**From:** [REDACTED]  
**Sent:** 07 April 2023 17:23  
**To:** Planning  
**Subject:** Planning application number 3/2023/0164 grid ref- 360045 436356

Bungalow on Mardale Road, application number 3/2023/0164

NEW DWELLING: LAND OFF CONISTON CLOSE, LONGRIDGE, PRESTON LANCS PR3	JM-0262	004	Rev-A
	PROPOSED ELEVATIONS		Date: 27.01.23 Drawn: J Monks Scale: 1:100 Size: A3
MONKS - ARCHITECTURAL - DESIGN			
25 BIRCHFIELD DRIVE - LONGRIDGE- PRESTON - PR3 3HP

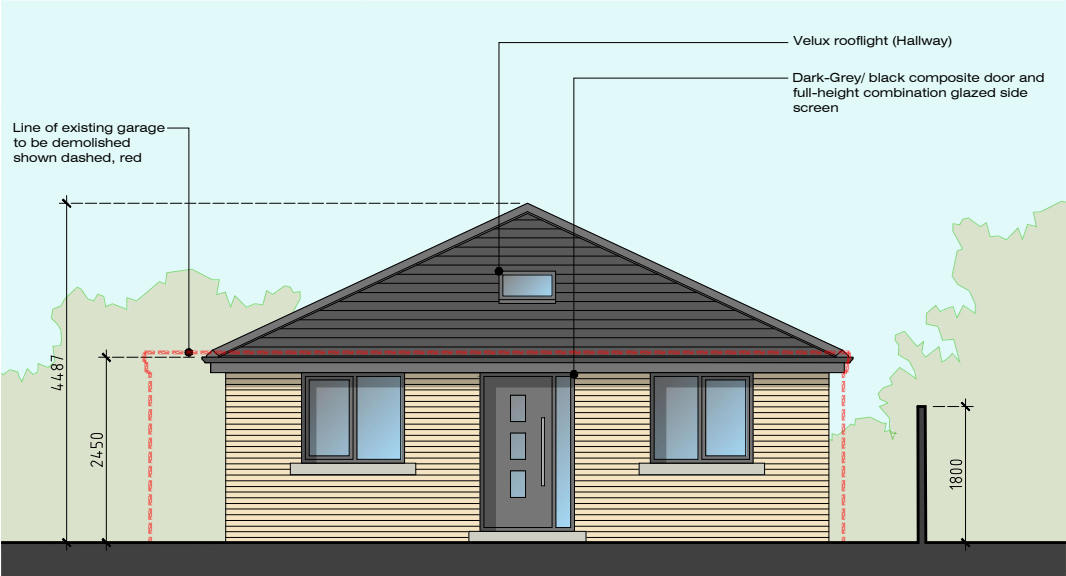
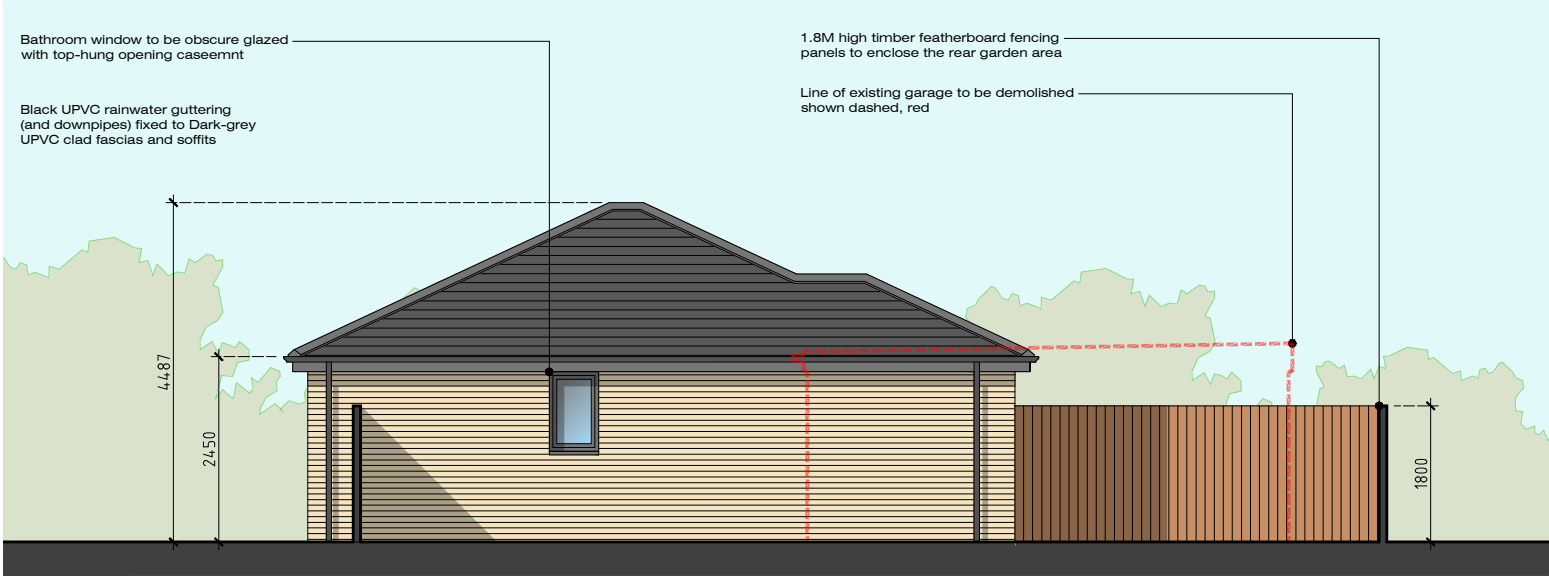
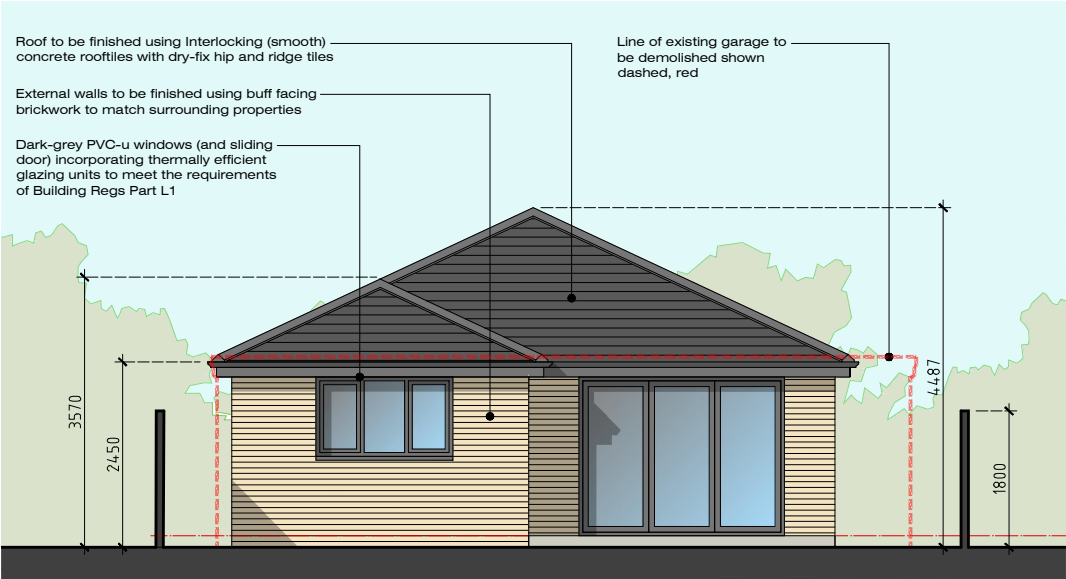
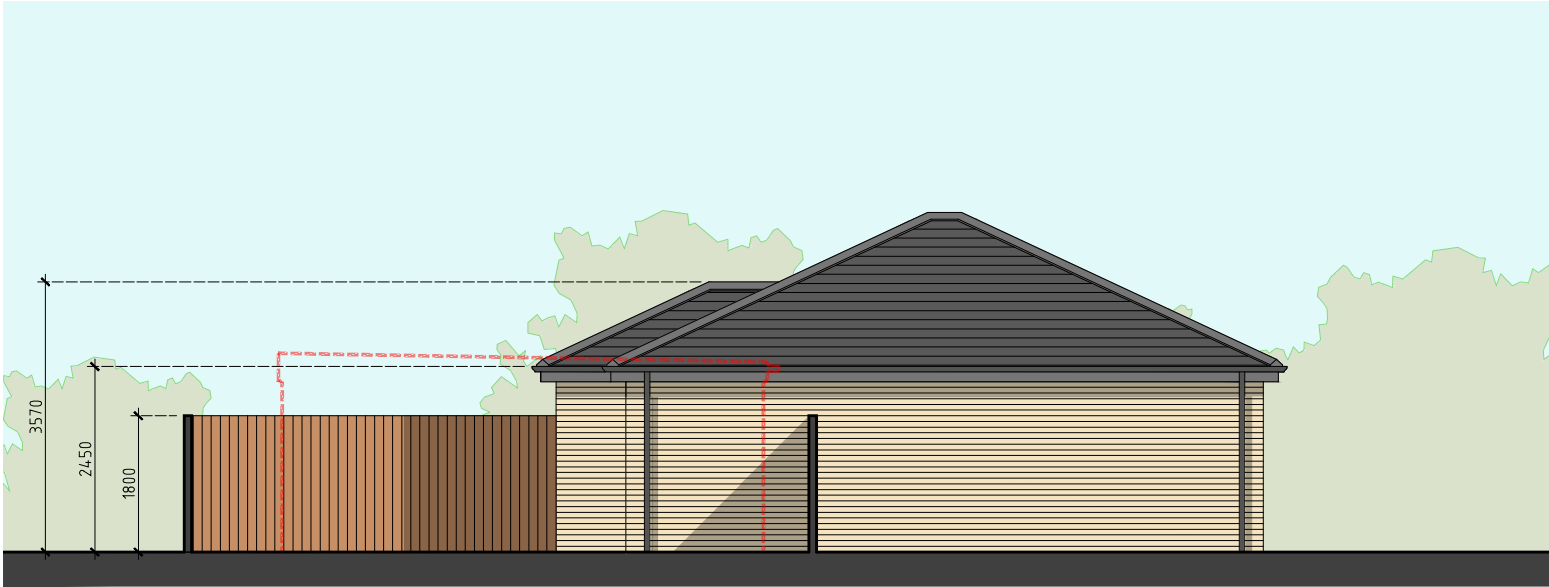
I write in connection with the proposed plans to demolish the existing garage block [REDACTED] I wish to object to the plans for the following reasons, I am very concerned it will [REDACTED] the plans appear that the new property and parking space is going to [REDACTED] which also makes me have to consider how would I then be [REDACTED] I already have [REDACTED] My other concerns are that not only will [REDACTED] but also the wagons making deliveries to the shop and properties around [REDACTED] use this area as a turning point, to stop them from having to go through the estate itself, so again if the plans went ahead where would it send these wagons. Can I also ask for clarification of the front south west elevation, it appears to differ on 2 of the different proposed elevation plans.

NEW DWELLING: LAND OFF CONISTON CLOSE, LONGRIDGE, PRESTON LANCS PR3	JM-0262	003	Rev-C
	PROPOSED SITE & FLOOR PLANS		Date: 27.01.23 Drawn: J Monks Scale: 1:100/200 Size: A3
MONKS-ARCHITECTURAL-DESIGN 25 BIRCHFIELD DRIVE - LONGRIDGE- PRESTON - PR3 3HP

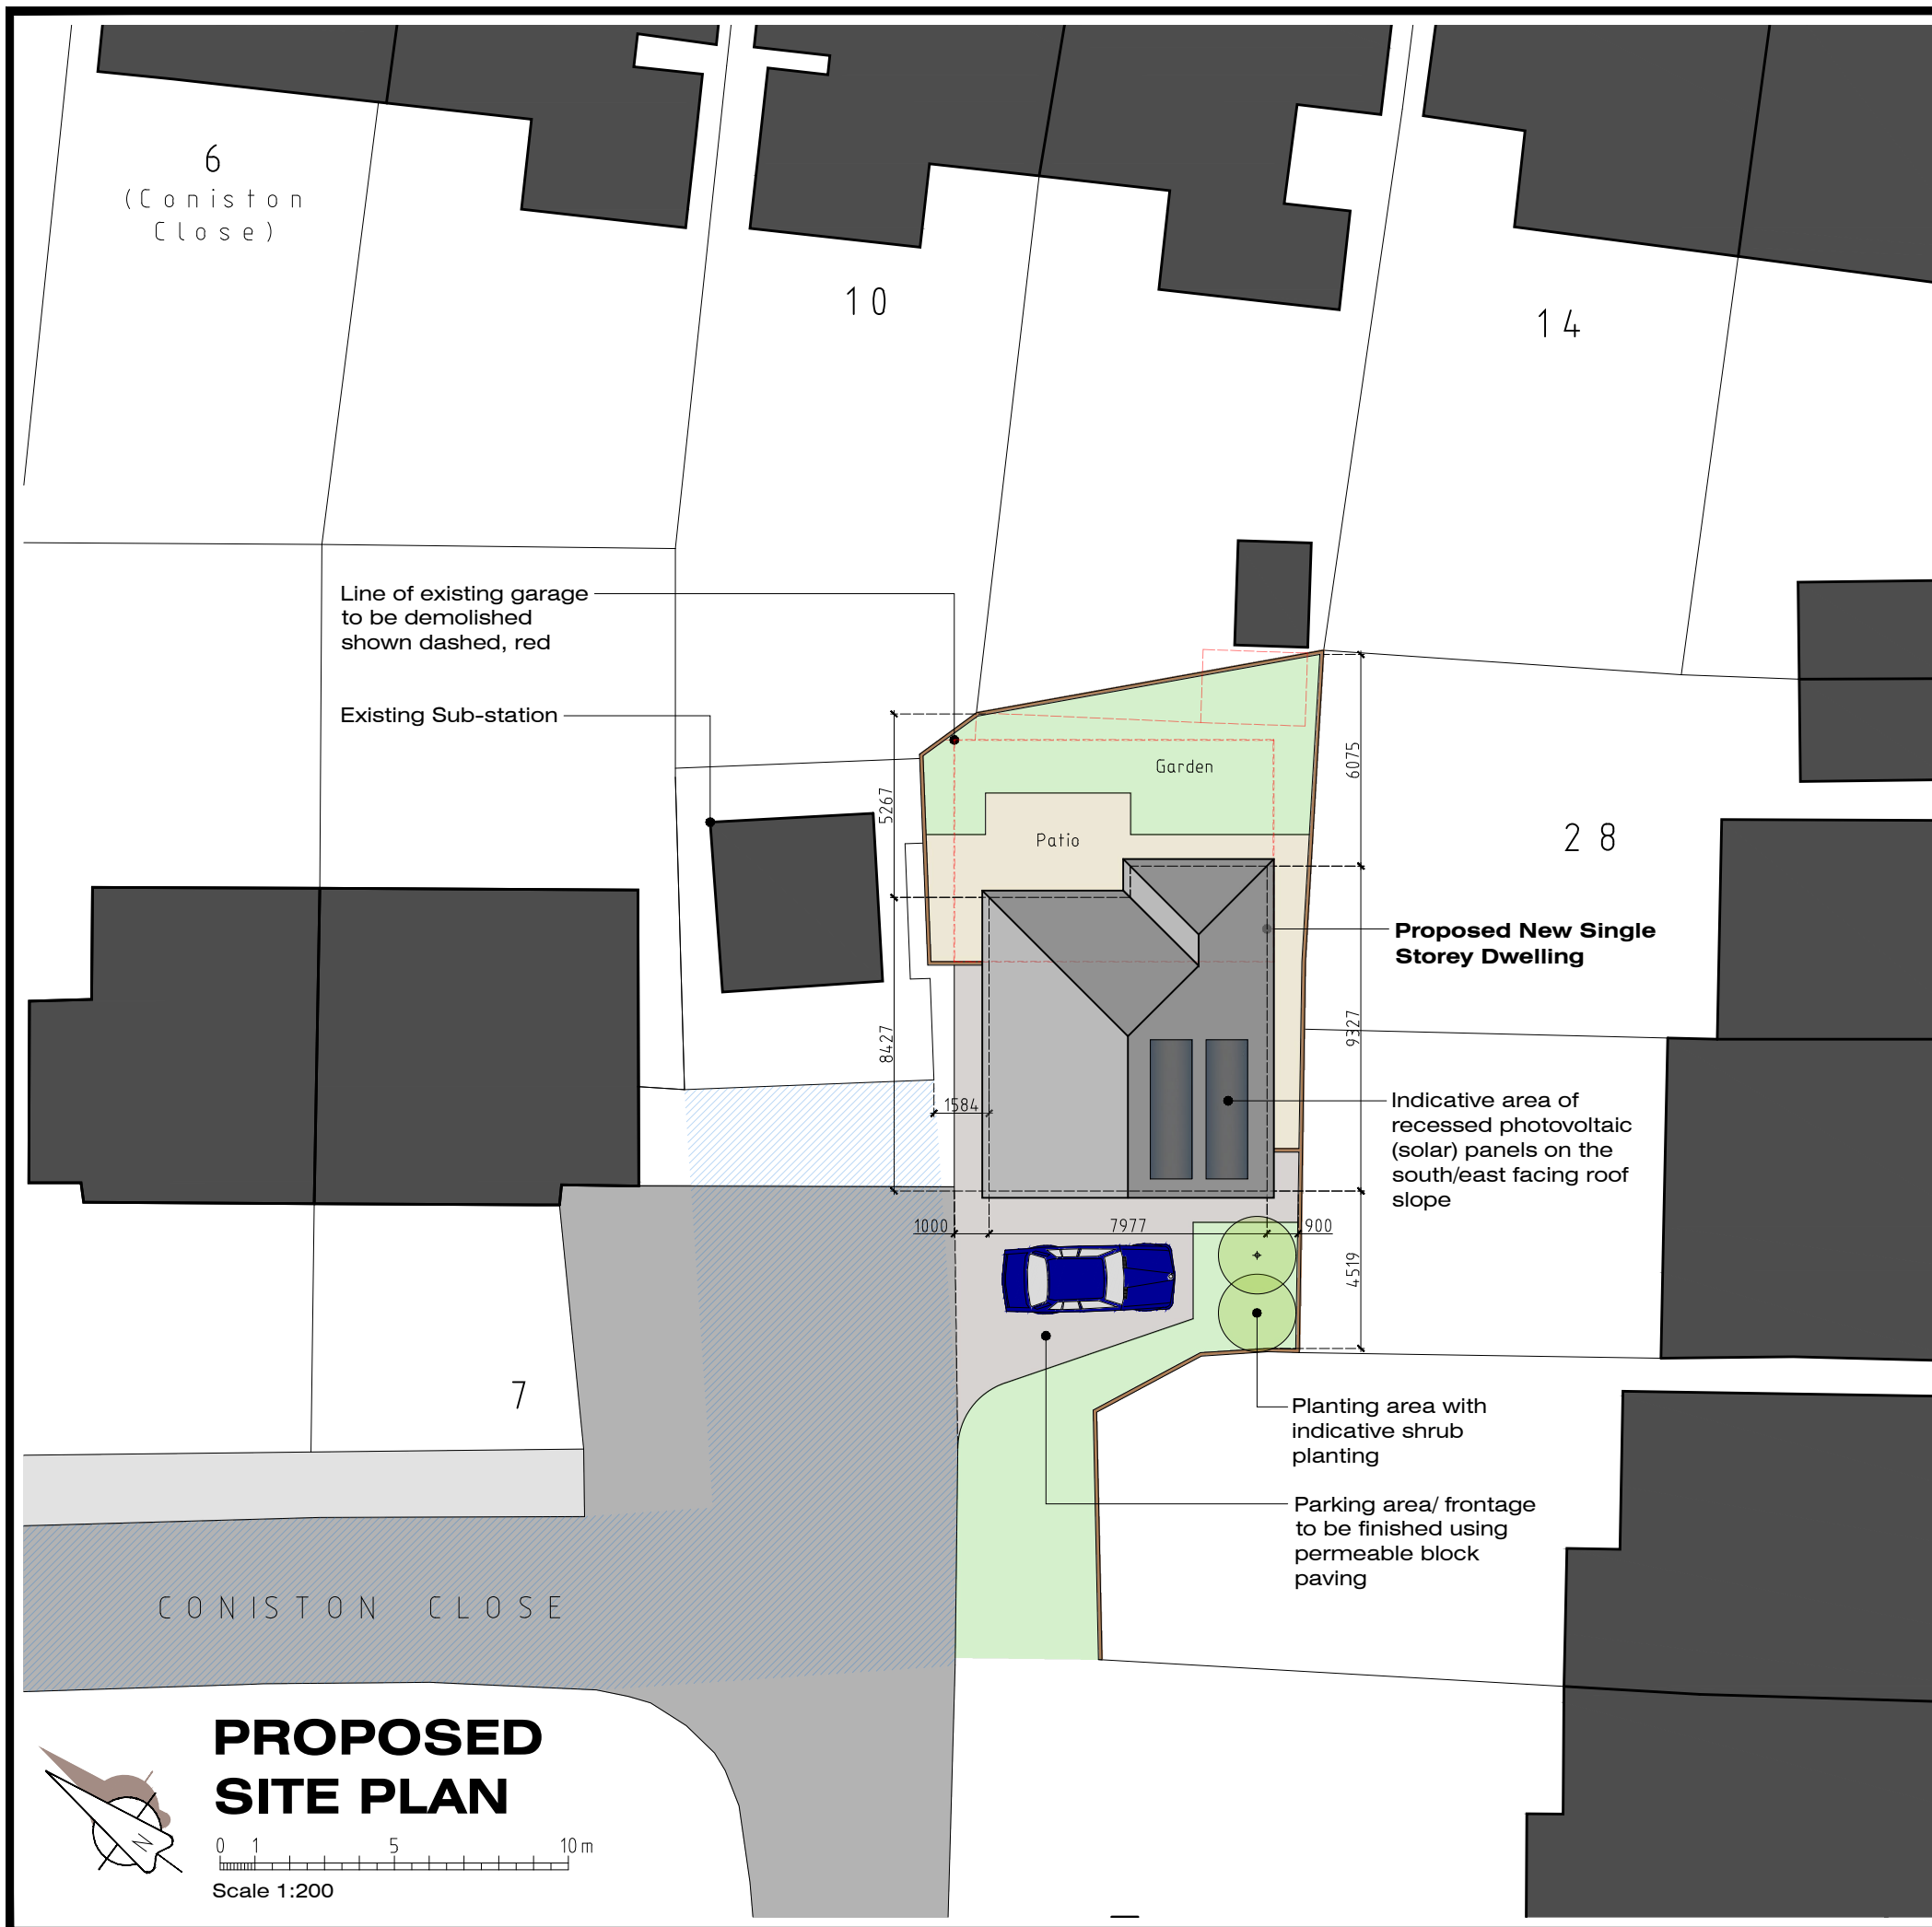
I have no objections to the building, in fact it will be an improvement to the area. I am concerned that the plans may not allow a turning area for the wagons delivering to the rear of the Premier supermarket on Mardale Road.

If the turning space has been preserved I have no qualms but the map seems to show number 8 Mardale Road's drive and garden as the turning space.
